National Grid Electricity Transmission Project

EN020026 : Sea Link

ACTEA Submission at Deadline 6

Re: Proposed use of Aldringham Lane B1353 by Cable Drum Carrier ALL vehicles and a number of ‘Smaller construction vehicles’

# **Suffolk Onshore Scheme Abnormal Load Routing Plan**

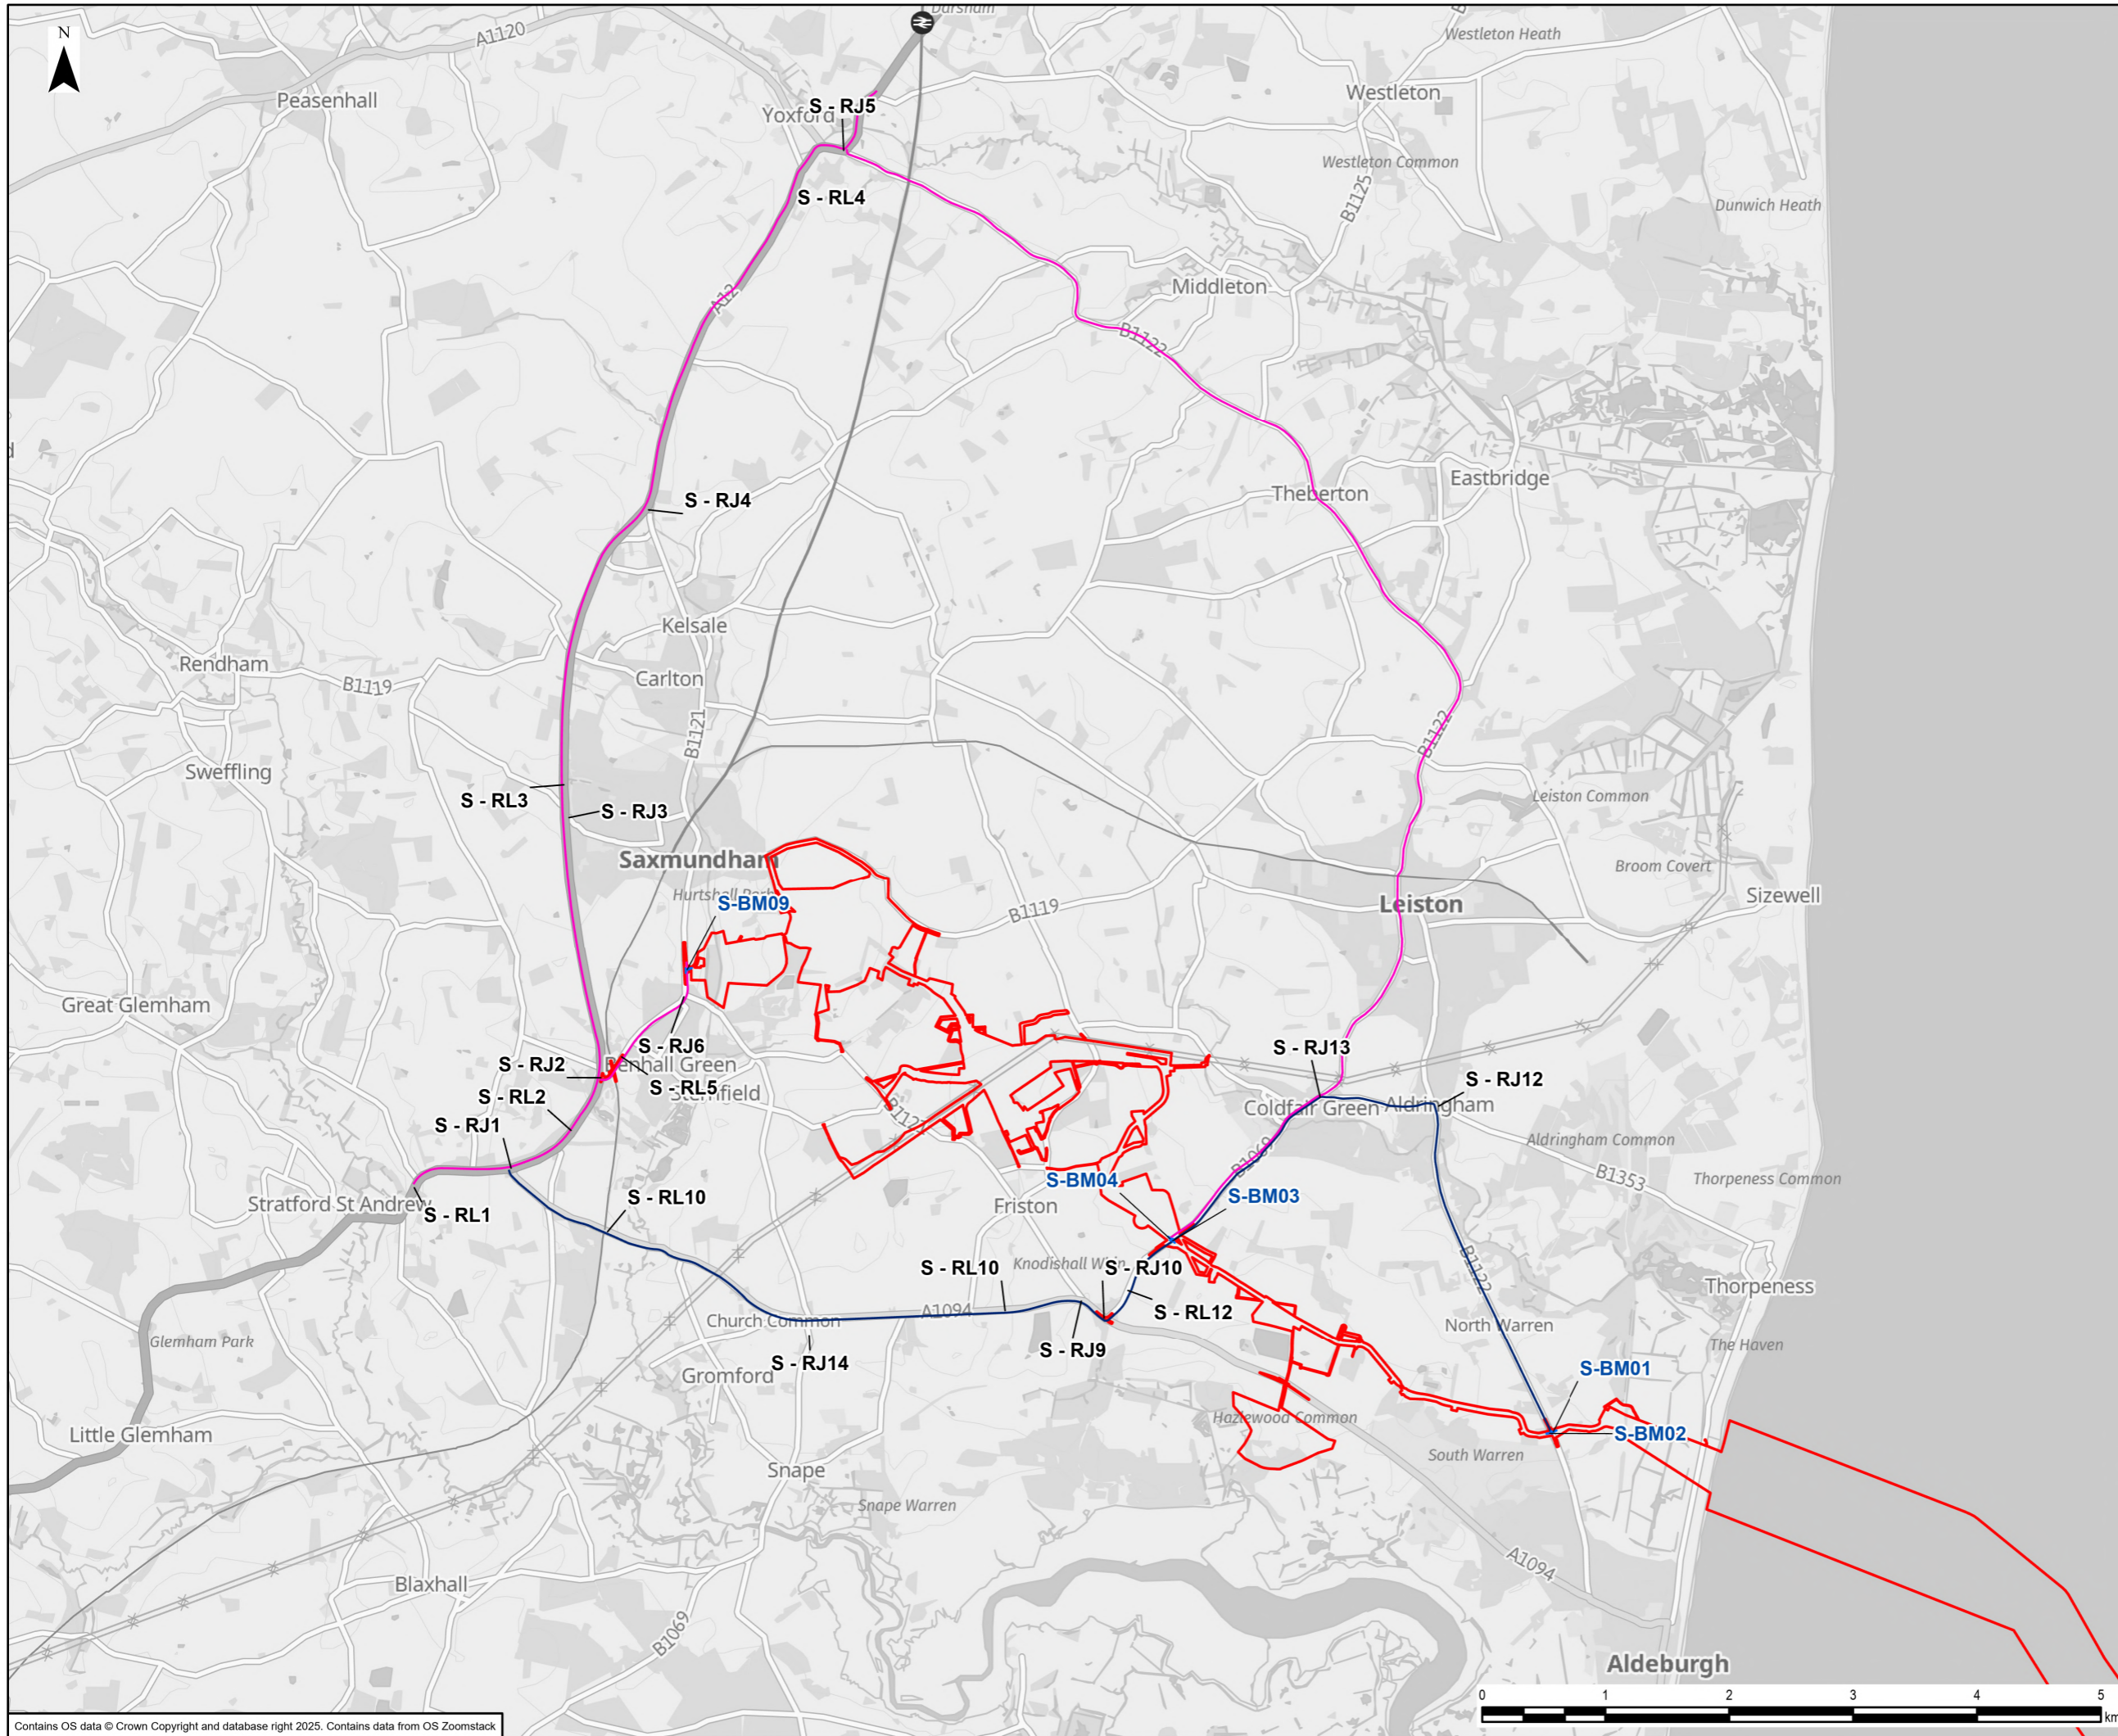
The Applicant has once again expressed its confidence that B1353 Aldringham Lane is suitable for cable drum movements, although having also acknowledged tight road junction geometry at AC10 / S-RJ13 B1069 through Knodishall and AC11 / S-RJ12 Aldringham Lane/ Aldeburgh Road junction that may necessitate junction widening at one or both junctions.

The Applicant's latest comments do not rule out the risk that junction widening may be required. It is conceivable that such widening could impact negatively on nearby dwellings. Therefore evidence is required in support of the Applicant's conclusions prior to ExA's final report to the Secretary of State, given that no alternative route has been proposed.

This matter has been raised repeatedly with ExA in writing throughout the examination. It now seems that it may best be resolved through ExA requiring of the Applicant that it submits the equivalent indicative swept path diagrams illustrating cable drum carrier paths at AC10 / S-RJ13 B1069/B1353 junction) and at AC11 / S-RJ12 (B1353/B1122 junction) superimposed over existing road and roadside features in those localities.
